# KITITITAS COUNTY DEPARTMENT OF PUBLIC WORKS

## MEMORANDUM

DATE: November 15, 2007

SUBJECT: Starlite Heights Performance Based Cluster Plat

COVER SHEET
OF
STARLITE HEIGHTS

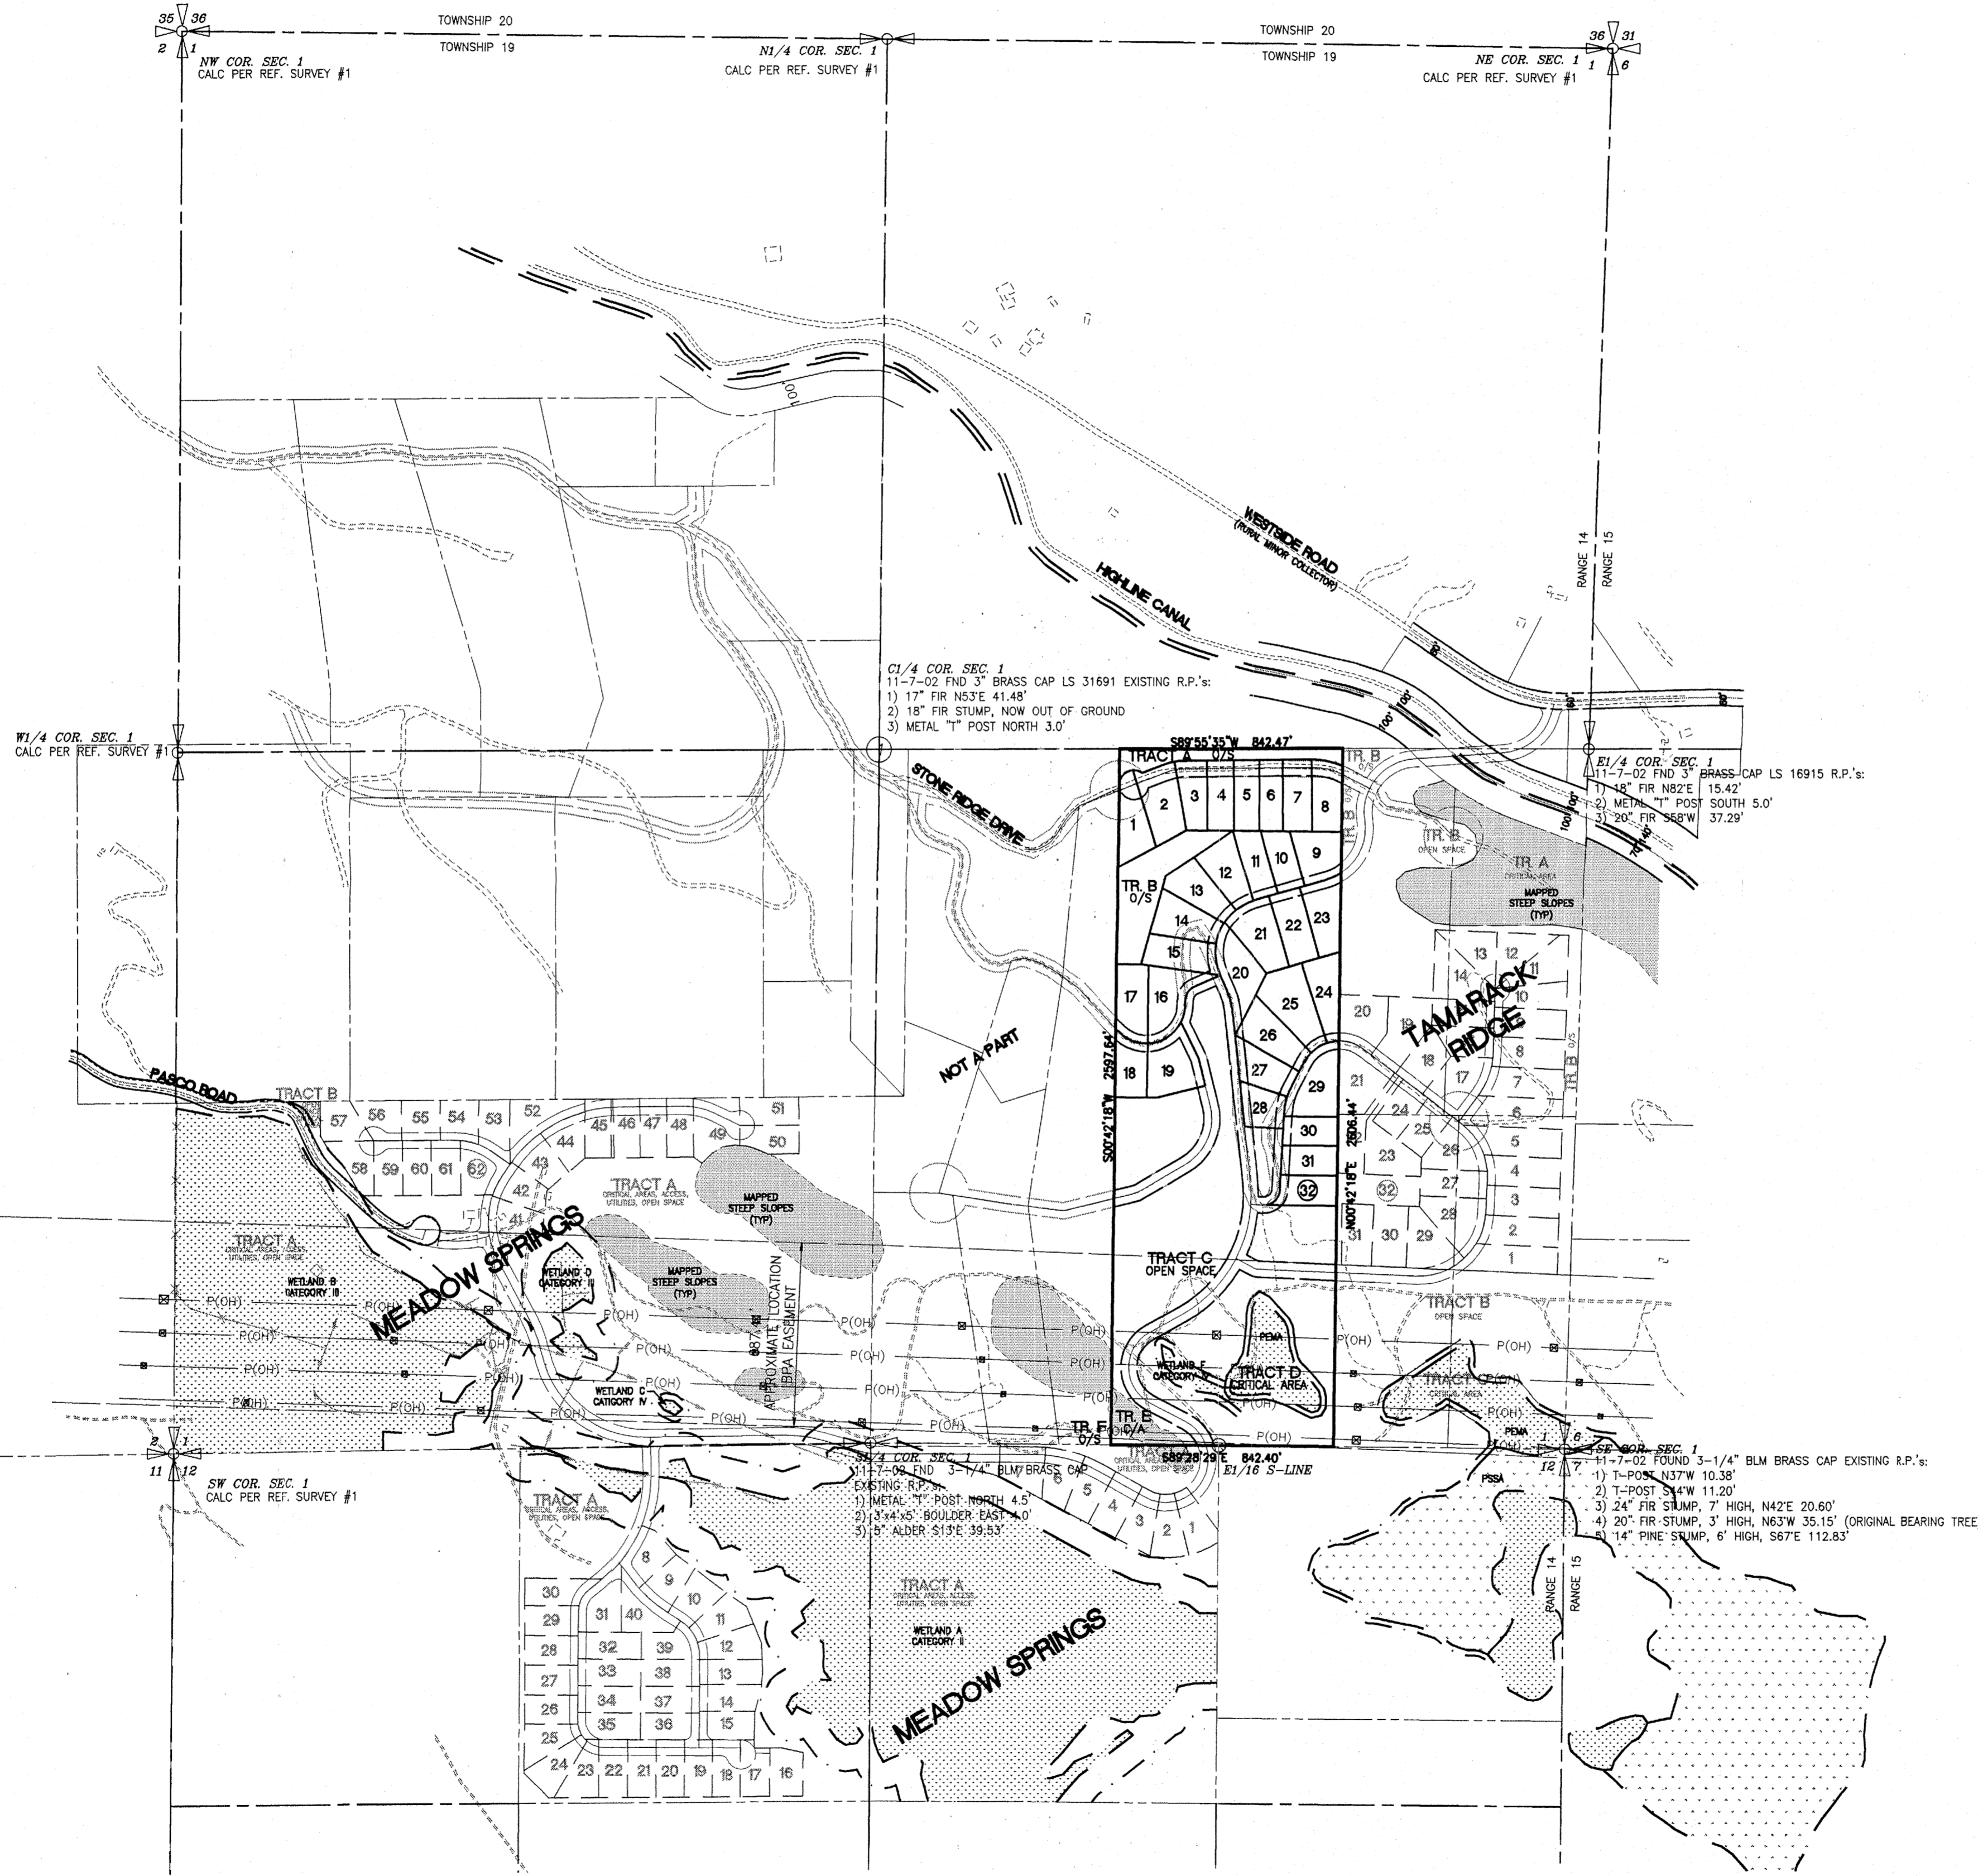
- a. Adjacent Property Owners: The adjacent property owners and surrounding properties shall be on the face of the final short plat. (K.C.C.16.20.040, 10, Plat drawing, Adjacent Owners).
- b. Surrounding Area: All surrounding property shall be shown in dotted lines and letters with names of plats, roads, adjoining lots, canals, and etc., and if unplatted shall be so indicated. (K.C.C.16.20.040, 11, Plat drawing, Surrounding Area).
- c. Receiving Number(s): The Receiving Number(s) are required on each page of the Final Plat Submittal.
- d. Plat Approvals: All plats must show the acceptance signature of the County Engineer. The acceptance block shall be as follows (per KCC 16.24.170):

SITE PLAN
OF
STARLITE HEIGHTS
A PORTION OF SECTION 01, TOWNSHIP 19 N., RANGE 14 E., W.M.
KITTITAS COUNTY, WASHINGTON

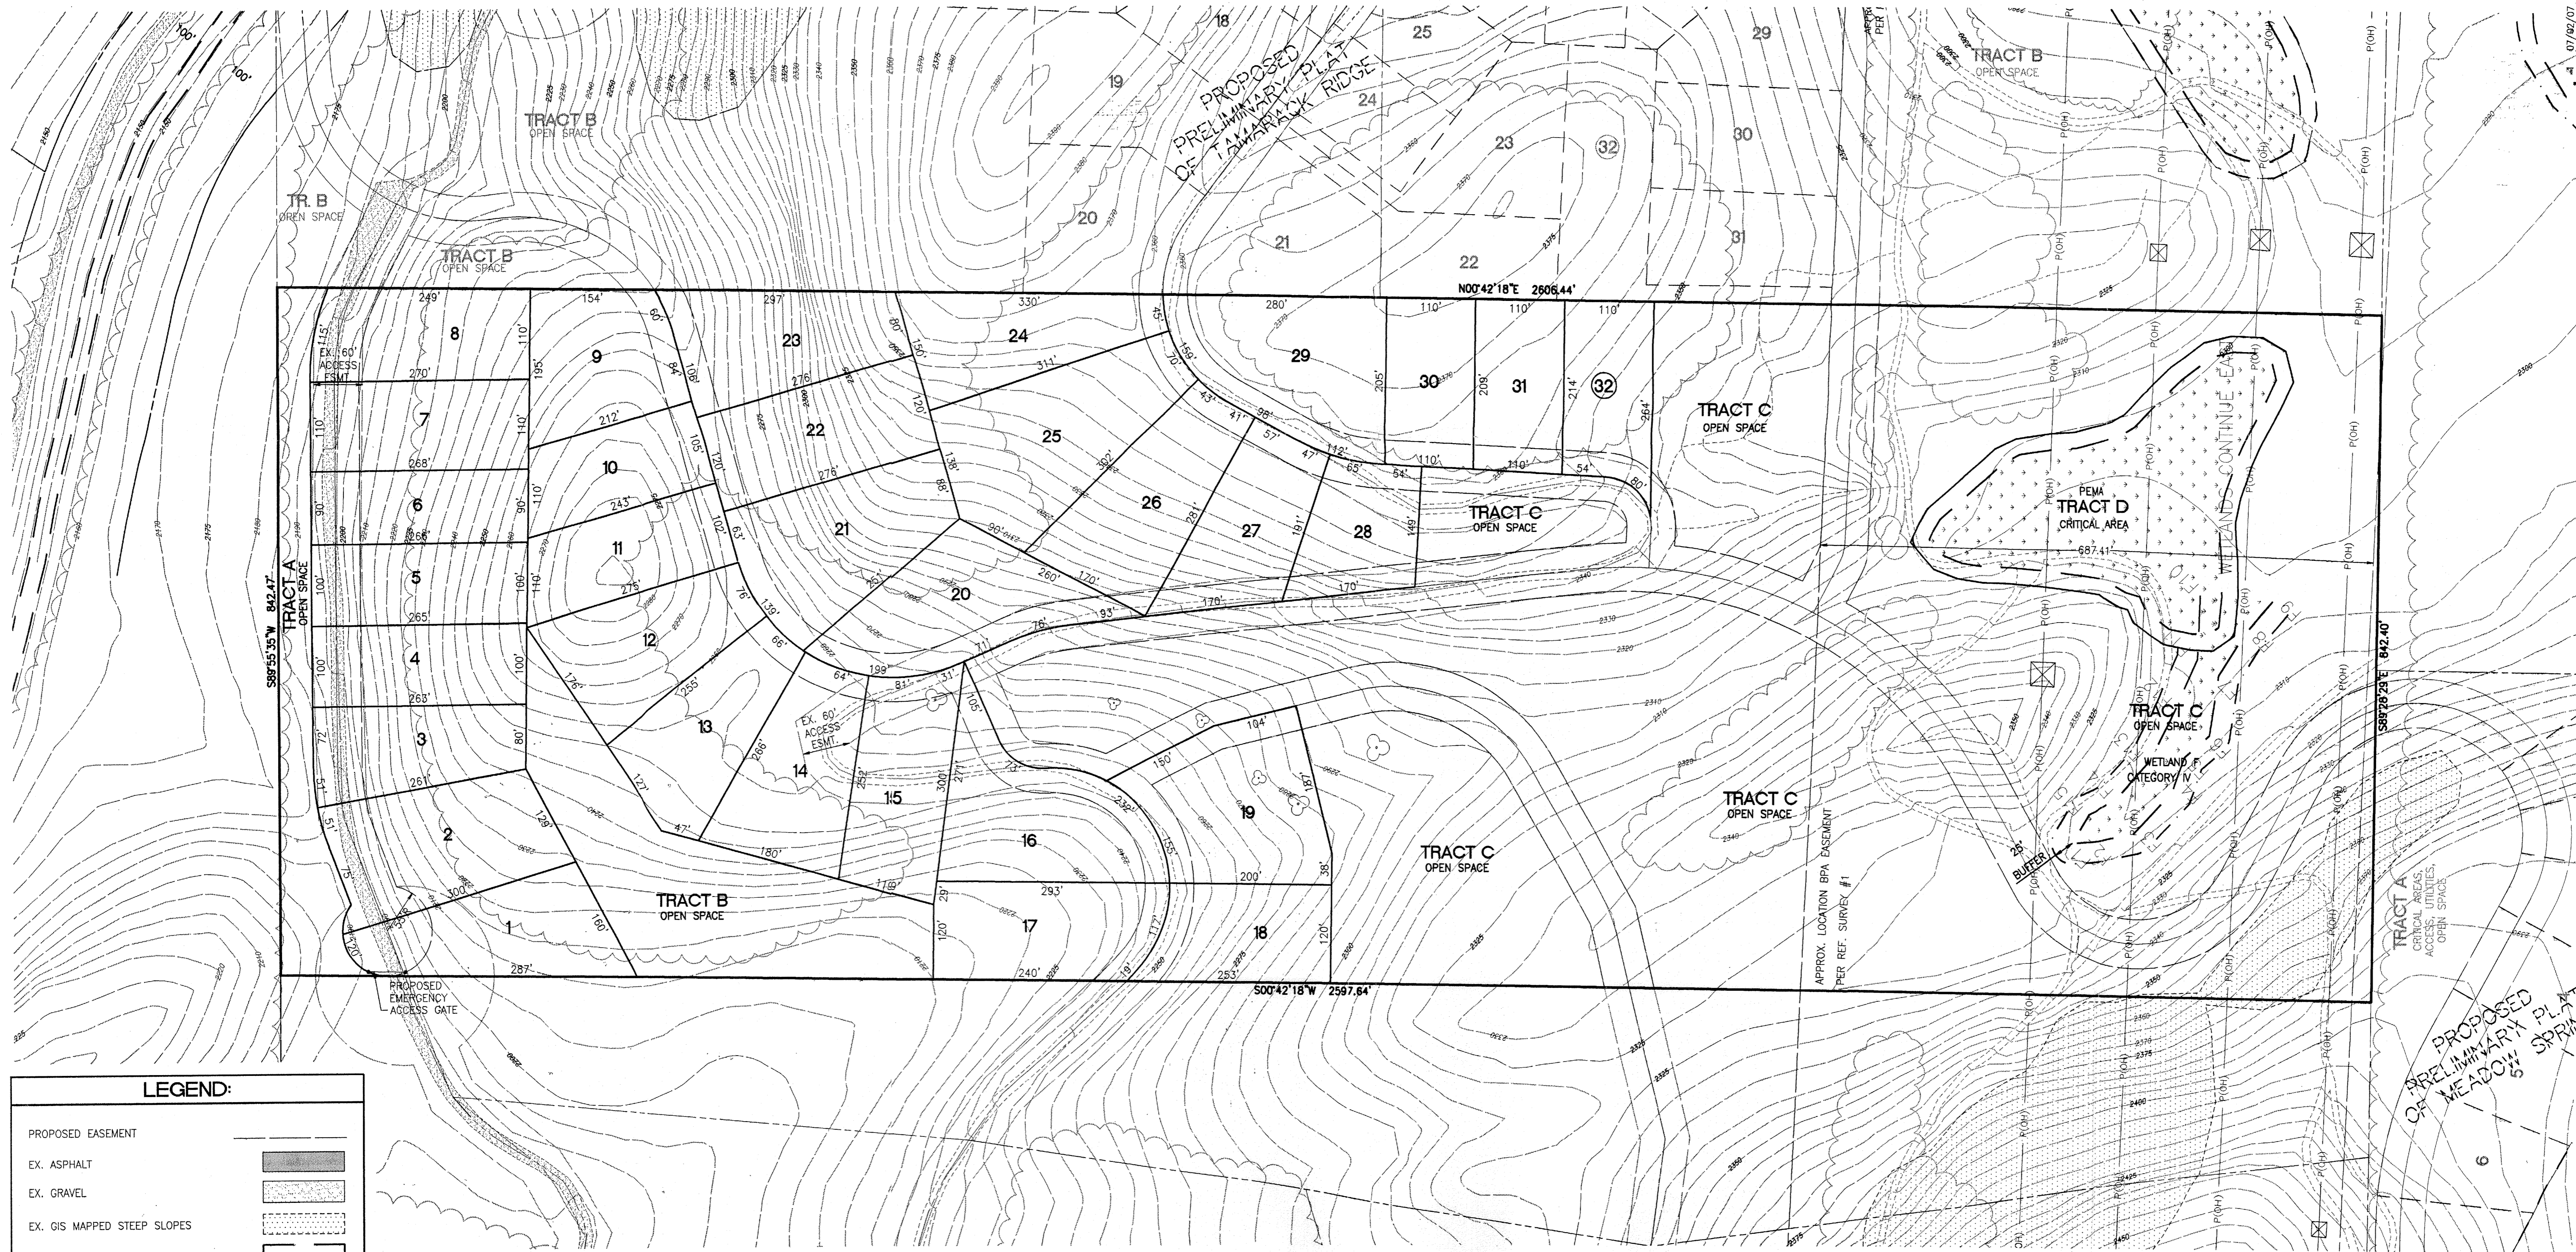
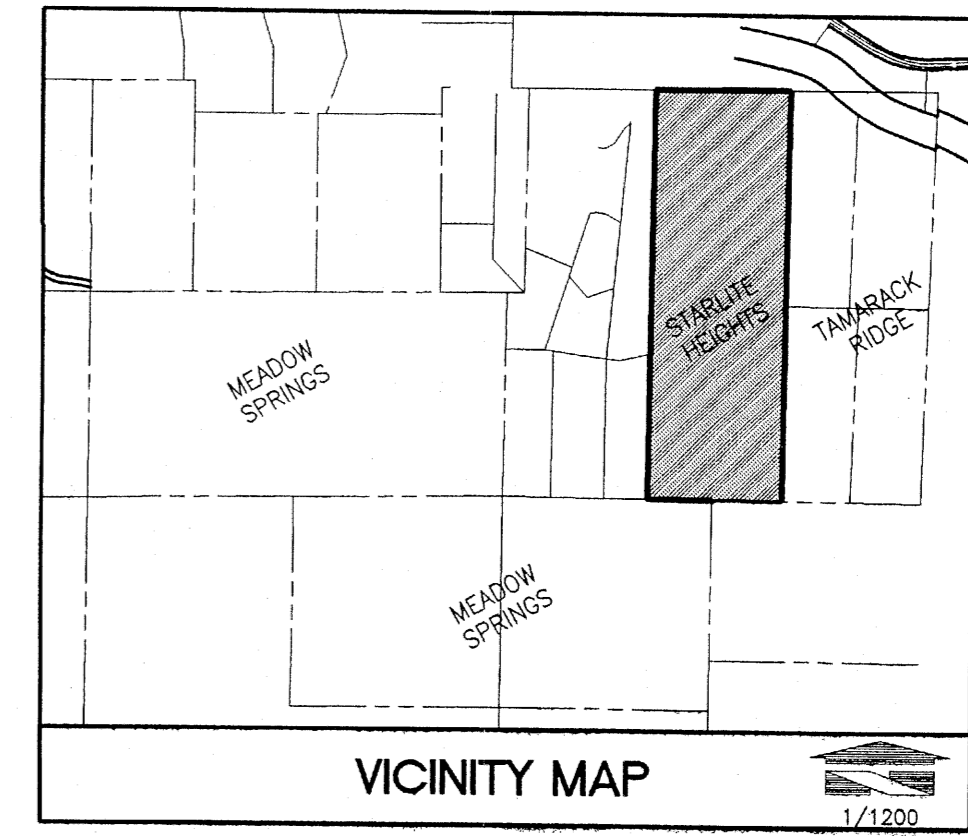
- e. Legal Description: The legal description on the plat does not match the legal description provided in the Subdivision Guarantee. The legal description on the plat shall match the legal description provided in the Subdivision Guarantee.
- f. 16.12.020 Preliminary Plat General Information:  
Unless otherwise specified, information required below may be placed on either sheet one or subsequent sheets or on all sheets as necessary.

16. Grade: The grade of some portions of the proposed road range from 6 percent to roughly 15 percent. The internal roads shall not exceed 12 percent grade according to KCC 12.20.050. To meet this standard developer will have to make appropriate cuts to obtain no more than a 12 percent grade. Developer should also take into mind that due to possible cuts a 60-foot right-of-way may not be adequate to meet side slopes and may require additional right-of-way.
